2023/0906

30A Fearn House Crescent, Hoyland, Barnsley, S74 0BA

Erection of detached treble garage outbuilding with first floor home office room above and 3no dormer windows set within the roof plane on the front elevation

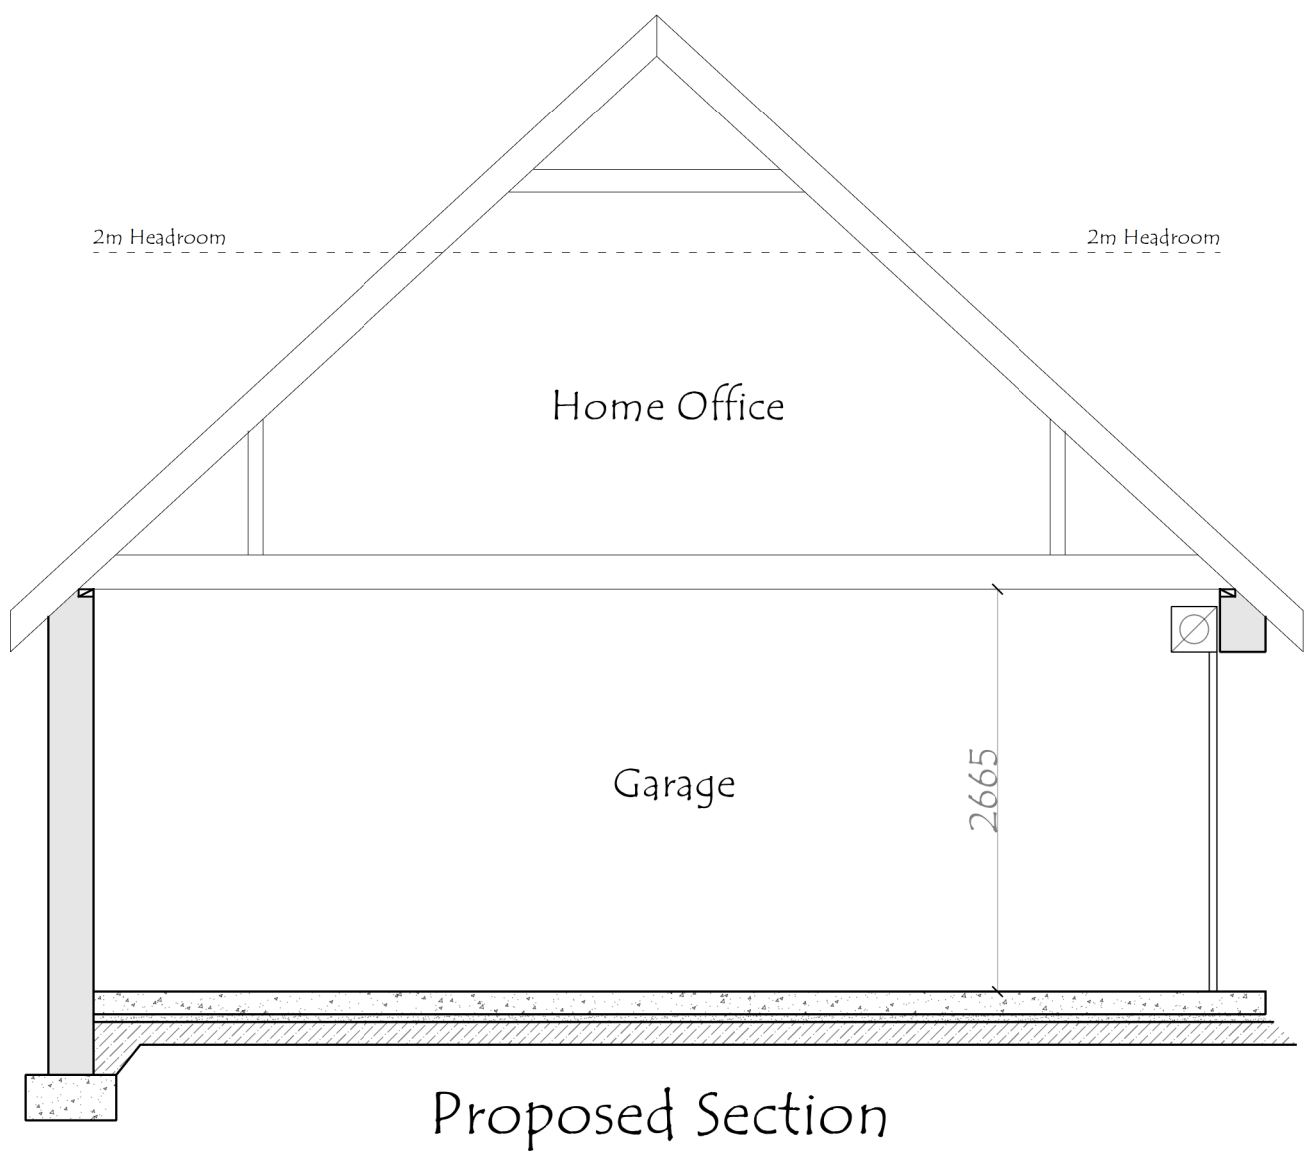
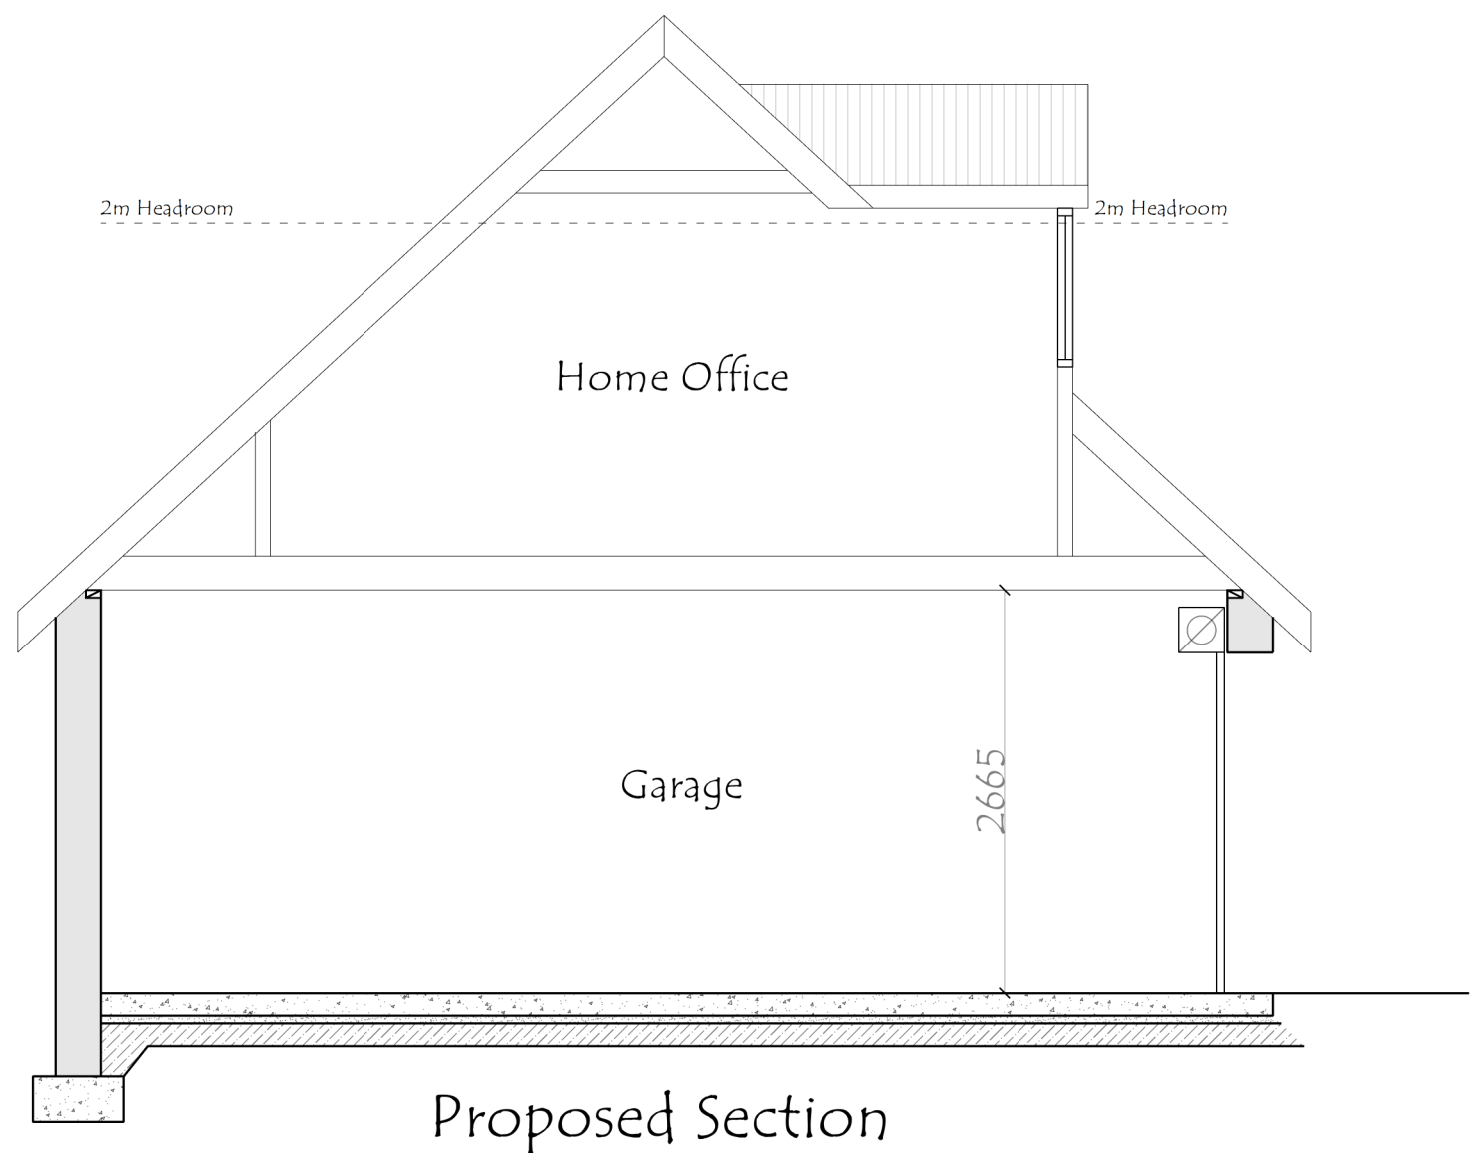
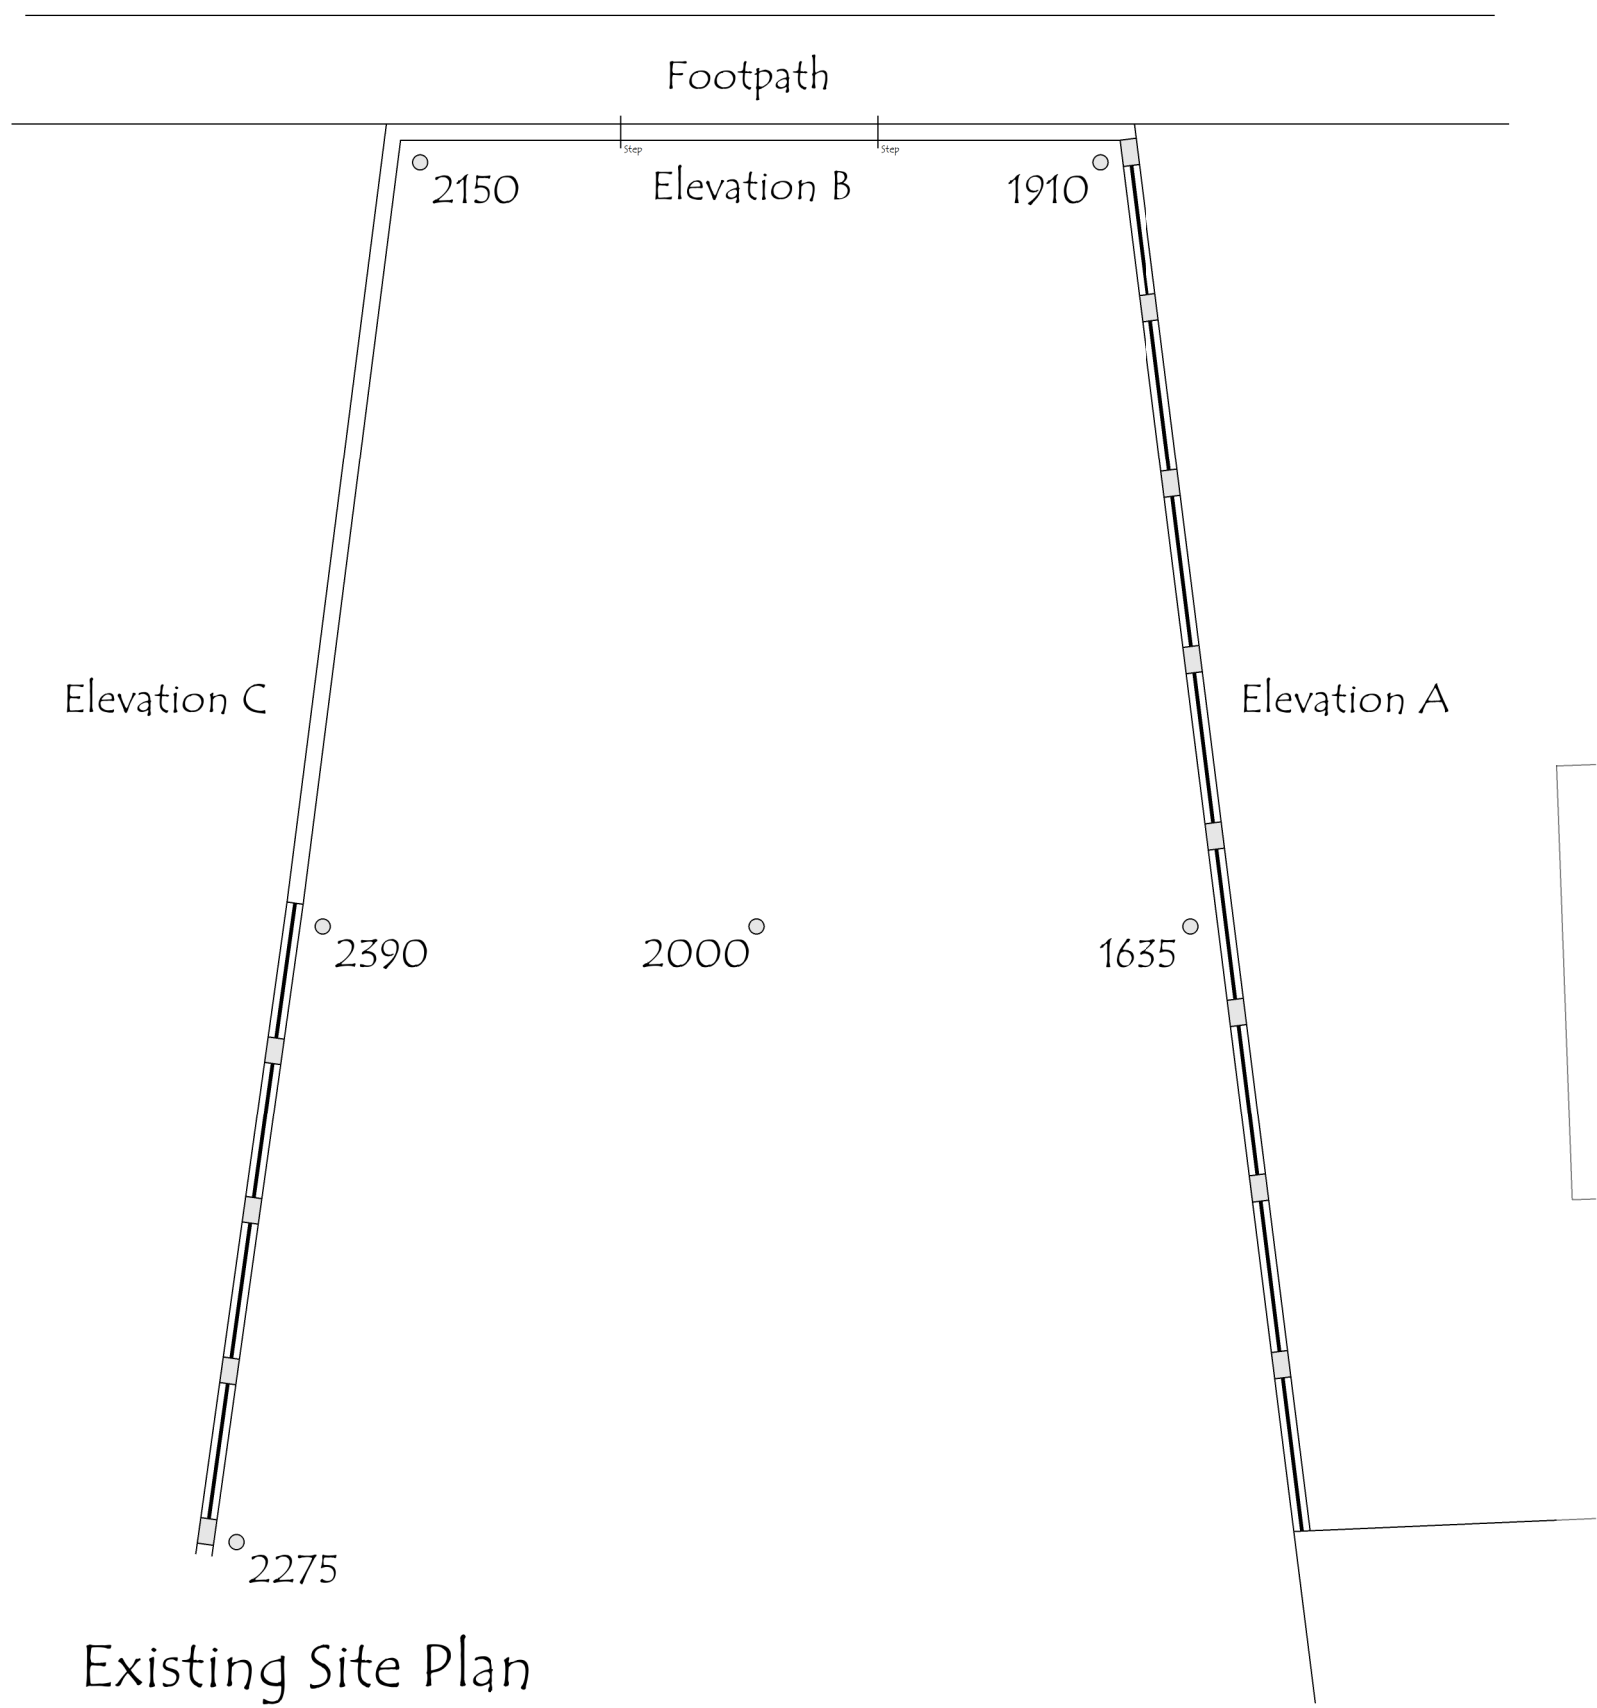
The SPD states that *“detached garages and outbuildings should be single storey structures and the eaves height should not normally exceed 2.5 metres from ground level, whilst the ridge height should not exceed 4 metres”*. The proposed garage has a pitched roof with an eaves height of 2.3 metres which is compliant. However, the proposed garage is proposed to be of two storeys and would have a ridge height of 6.2 metres. The additional storey and roof height over the recommendations of the SPD are not acceptable.

Single storey residential properties are set directly to the side (north & south) of the proposed garage. These properties are 282A West Street to the north and 12 & 14 Fearn House Crescent to the south. The SPD states with regards to habitable room windows that *“a distance of 12 metres should be maintained to a blank gable wall”*. In this case the blank gable wall is that of the proposed garage. The habitable room windows on the rear elevation of 282A West Street are 7 metres away from the proposed garage which is 5 metres short of the recommendation and therefore unacceptable. This weighs substantially against the proposal.

The habitable room windows on the rear elevation of 12 & 14 Fearn House Crescent are 11 metres away from the proposed garage which is 1 metre short of the recommendation and although not as egregious as the impact would be to 282A West Street, it is still unacceptable. The proposed garage would be considerably overlooked from the adjacent dwellings and cause a harmful loss of outlook to the rear elevations of the impacted dwellings. This weighs significantly against the proposal.

The SPD states *“it is not considered appropriate for detached garages to include dormer windows as a way of accommodating rooms in the roof space”*. The proposed garage features dormer windows to its front elevation and alongside the excessive height and scale would give the development an overly residential appearance, rather than that of an ancillary outbuilding. Whilst the dwelling is set back from the road, it will be highly visible from neighbouring properties, and it is considered to punctuate the character of development in the area. It is considered that a garage of this size and scale would appear as an incongruous and dominant feature and would be at odds with the general development pattern of the area and would harm the visual amenity of the area in conflict with policy D1. This weighs significantly against the proposal.

The SPD states that *"proposals for garages will be assessed using the reference of a standard size for a single garage as outlined in the South Yorkshire Residential Design Guide, for double garage proposals a standard floor area size is considered to be 6.5m x 6.5m"*. Whilst it is acknowledged that the proposed garage is proposed to be a triple garage, it is nevertheless considered that it is in conflict with the spd on this point, as the garage would be a very large two storey structure in terms of both footprint and internal floor space. The footprint size of the garage alone measures 77sqm. This is excessive for a domestic outbuilding and would exceed the minimum floorspace expected for a two-bedroom bungalow in the adopted South Yorkshire Residential Design Guide (SYRDG) of 62sqm. Together with the second storey, the internal floorspace would exceed 100sqm which is larger than the minimum size for a 4 bed dwelling as set out in the adopted South Yorkshire Residential Design Guide. The size of the extension is therefore tantamount to the size of a new two storey dwelling. This weighs significantly against the proposal.

Site Plan 1:500

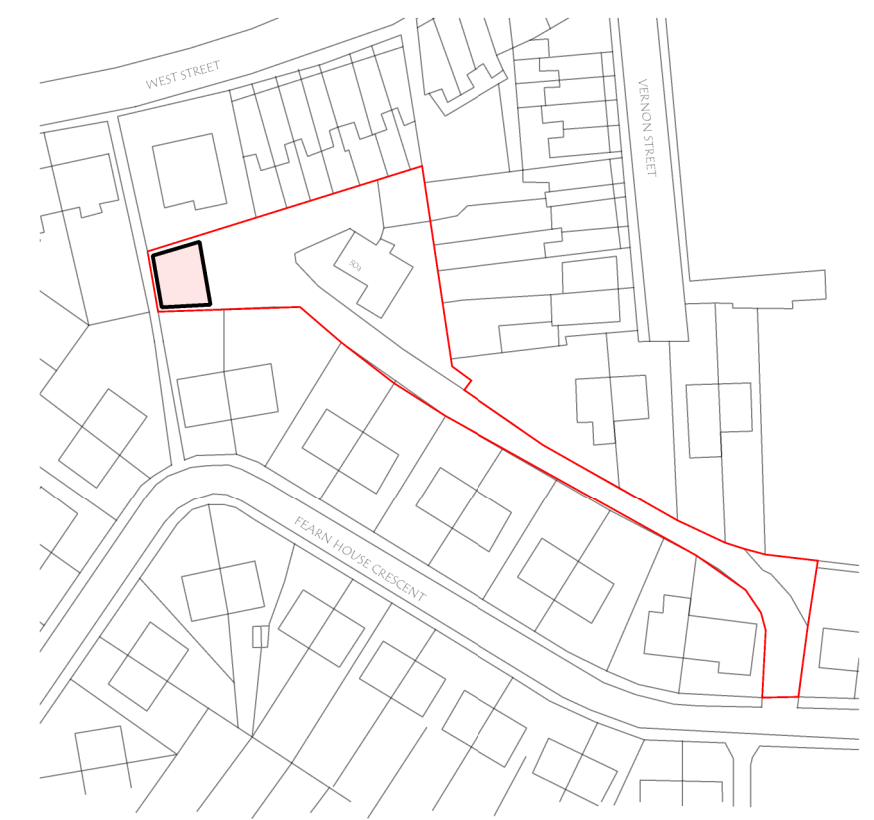
Finally, the proposed garage is situated to the south of neighbouring properties on West Street and extensions and outbuildings situated directly to the south of neighbouring properties and their garden areas generally have a greater overshadowing impact due to their positioning and the movement of the sun throughout the day. The proposed garage is of a significant size, scale and massing with a high roof ridge height which far exceeds the height of the existing boundary treatment and any boundary treatment that could be erected without planning permission. It is therefore deemed that the proposed garage would cause a significant overshadowing of 282A West Street, its rear habitable room windows and its rear garden area. As such the proposal is not in compliance with Local Plan Policy D1 in that it is of poor design and would also be in conflict with Local Plan Policy GD1 in that it will have a significant adverse effect on the residential amenity of existing residents. This weighs significantly against the proposal.
